**Consultation Response from KC,
Ecology Unit**

2026/90830 adj, 711, New Hey Road, Outlane, Huddersfield, HD3 3YL

Outline application for erection of residential development

Date Responded: 30/04/2026

Figure 2: Proposed Habitat Map

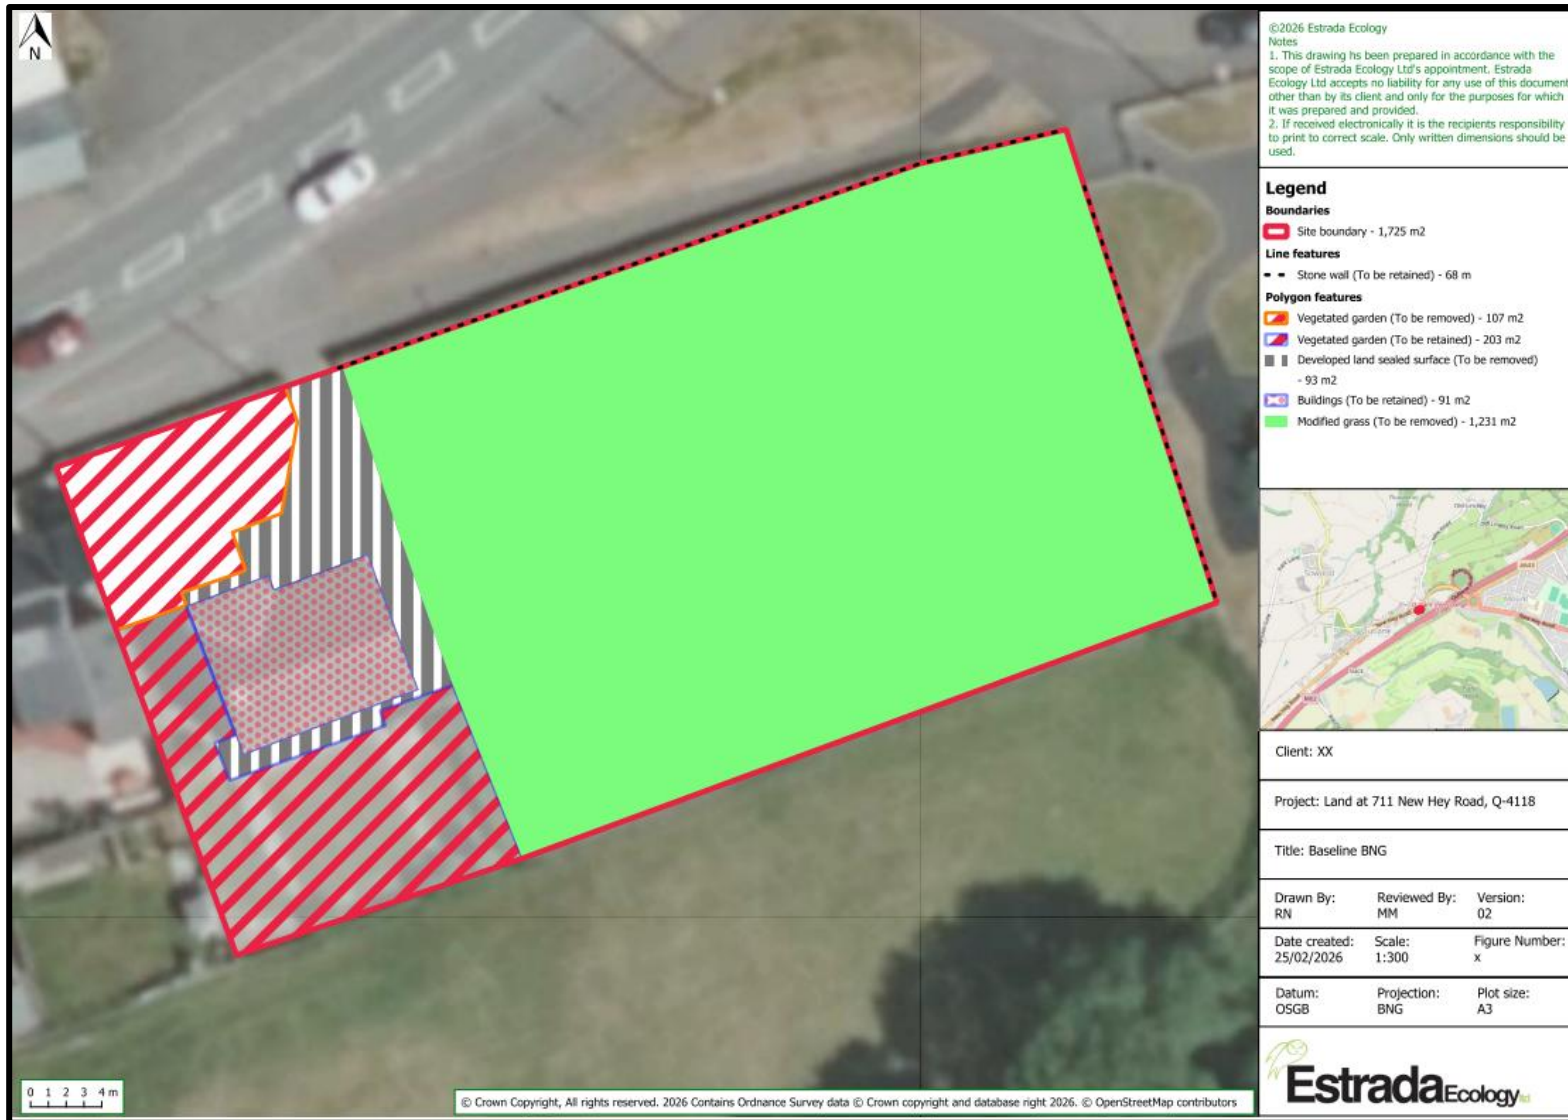
Although the submitted Biodiversity Net Gain (BNG) metric shows that >10% net gain can be achieved onsite through the creation of modified grassland, urban trees and mixed scrub, I am not satisfied that this is appropriate in terms of design or deliverability. The plans proposed 3 islands of mixed scrub immediately adjacent to the new dwellings, with an urban tree within each. Practically mixed scrub would contain species such as hawthorn, hazel, holly, dog rose, bramble and blackthorn, and the tree species should grow up to at least 3m tall. Many residents may consider this 'messy' and it is very likely that it will result in residents cutting or removing it, especially if it is effectively in their front garden. It is also unlikely that the individual trees planted within the scrub will establish well, and successfully grow above the height of the scrub, nor am I confident that a single urban tree is appropriate habitat delivery when contextualised in the area of mixed scrub.

Finally, I would also note that the mixed scrub has been input into the BNG Metric as a single habitat parcel, but the submitted plans show 4 separate locations where mixed scrub is proposed. Where non-contiguous parcels are included in the BNG Metric, these should be input as separate rows within the metric, to adequately represent the habitats to be created.

I would therefore recommend that the scheme layout is revised to ensure that appropriate, deliverable BNG enhancements can be included.
